21 Boundary Street  
Darlington NSW 2008  
13 May 2018

Development Application SSD 8636  
Location University of Sydney, darlington Campus  
Applicant: University of Sydney

I refer to the above development application and object to how Shepherd Street Darlington has been treated in the application

1 SHEPHERD ST ELEVATION
A-DA-3005 SCALE 1 : 200

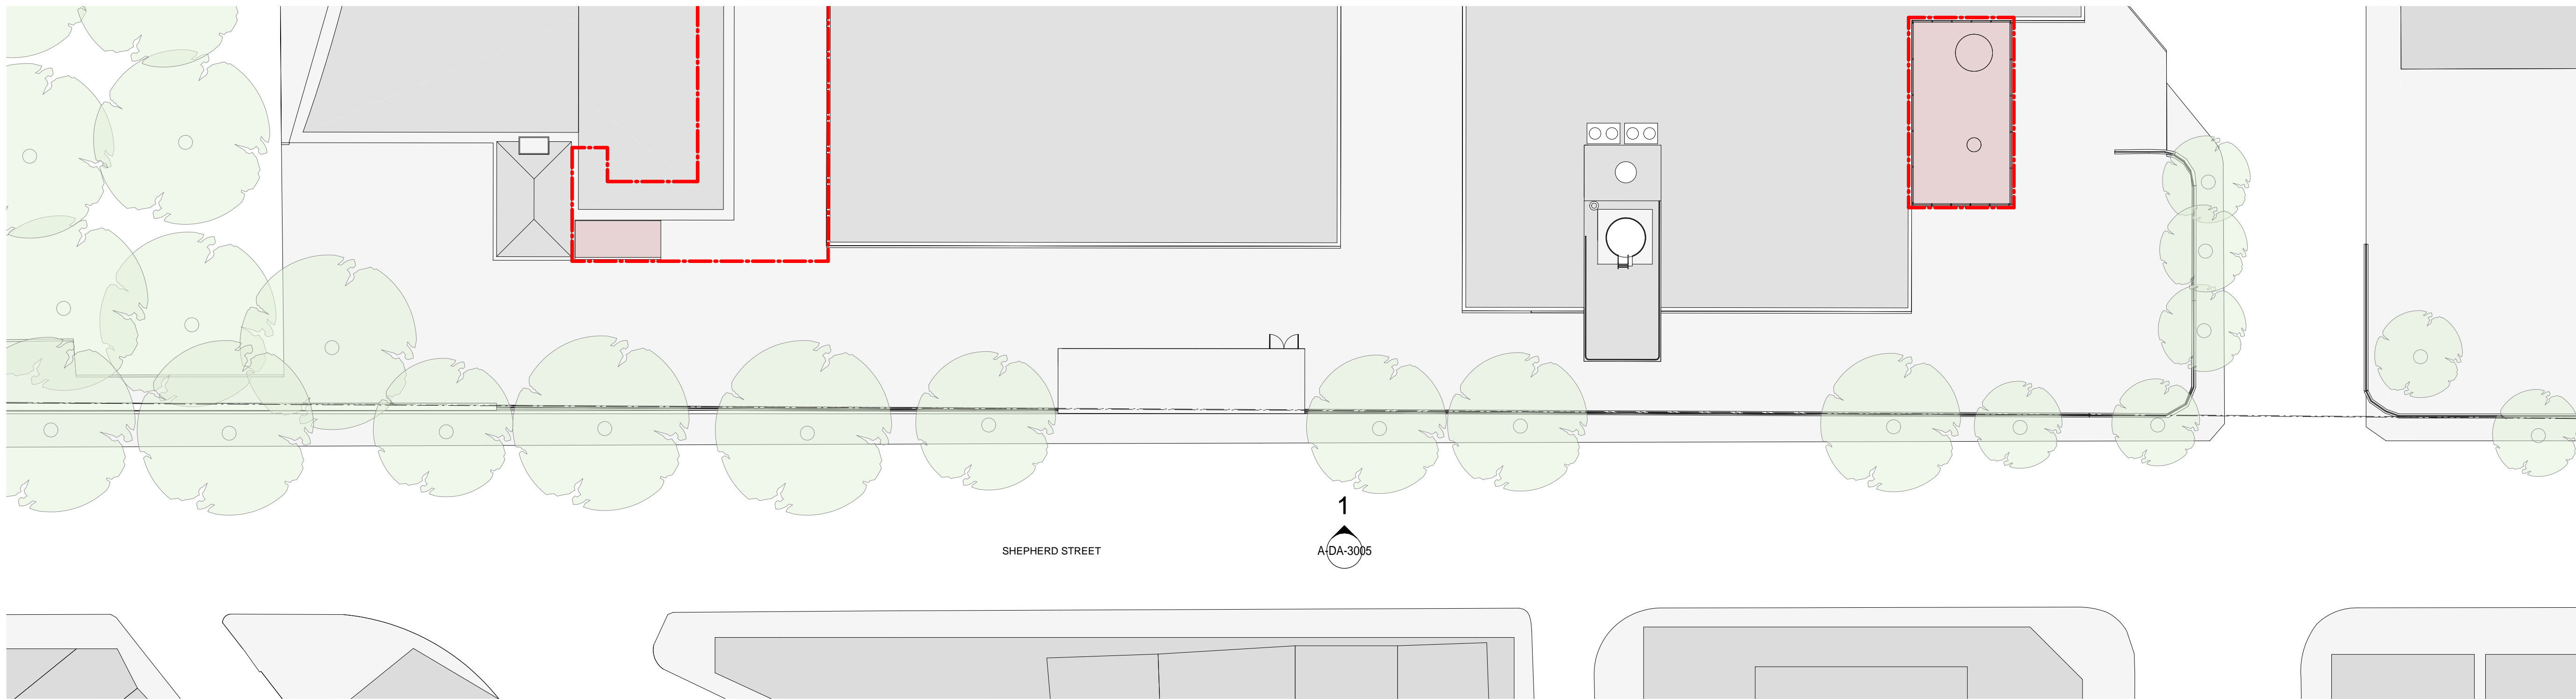
The 2 new abominations are shown in plan and elevation A-DA-3005. One is a bulk Cryo gas store and another is a gas store (attachment 5&6)..... just what we as residents and the public want to look at all day.

These plant rooms should be build inside the campus and not visible to the street and the residential properties of Shepherd street. There are a lot of internal road in the Uni that can provide access to these plants rooms without the public users and residents having to stare at them

1. Can you demand these 2 plant rooms be inside the campus and not visible from the street.
2. Can you demand that a plan to improve the appearance of the Uni when viewed for Shepherd Street between Cleveland street and Abercrombie street be prepared and exhibited for public comment.
